Deadline 9 Response to ISH11 and ExQ3. Question to the Environment Agency reference the offshore wave-relief features—the Sizewell-Dunwich banks and the inner and outer longshore bars.

This paper is a response to the Applicant's replies to enquiries made by the Planning Inspectorate relating to my documents. Author: Nick Scarr, IP 20025524

The Sizewell-Dunwich Banks. The purple arrows mark 26700N— to the north of which the crest height of Dunwich bank is lowering. Chart base from BEEMS Technical Report TR500 'Sizewell-Dunwich Bank Morphology and Variability'. Page 14. Markup my addition.

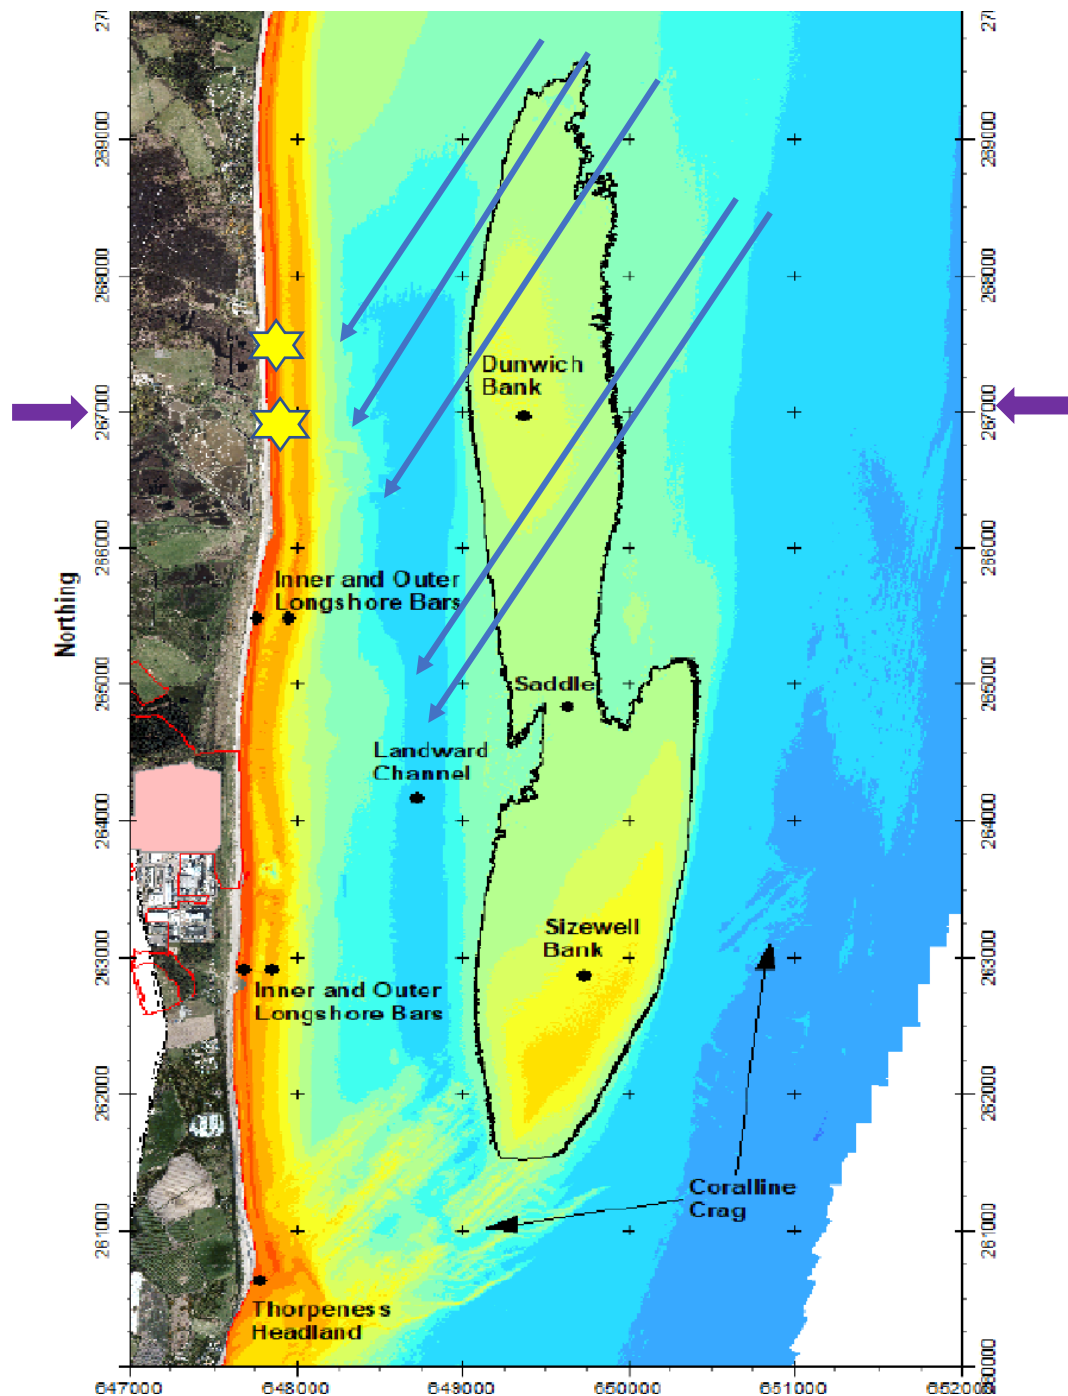
Would the Environment Agency please explain why it fully supports the approach of the Applicant in treating the major offshore wave relief features—the Sizewell-Dunwich banks and the inner and outer longshore bars as immutable (unchanging) over the proposed Sizewell C lifetime and that this approach represents conservative (precautionary) modelling.

My view is that the Applicant's approach is clearly contrary to both academic research and its own research pre-DCO and could represent an underrated flood and erosion risk to the proposed development.

My view, based on historical precedent and academic research, is that the significant erosional stresses to the shoreline occur due to North-easterly to Easterly storms and consequently that the Dunwich bank specifically protects the shoreline in the area of the proposed Sizewell C and Minsmere.
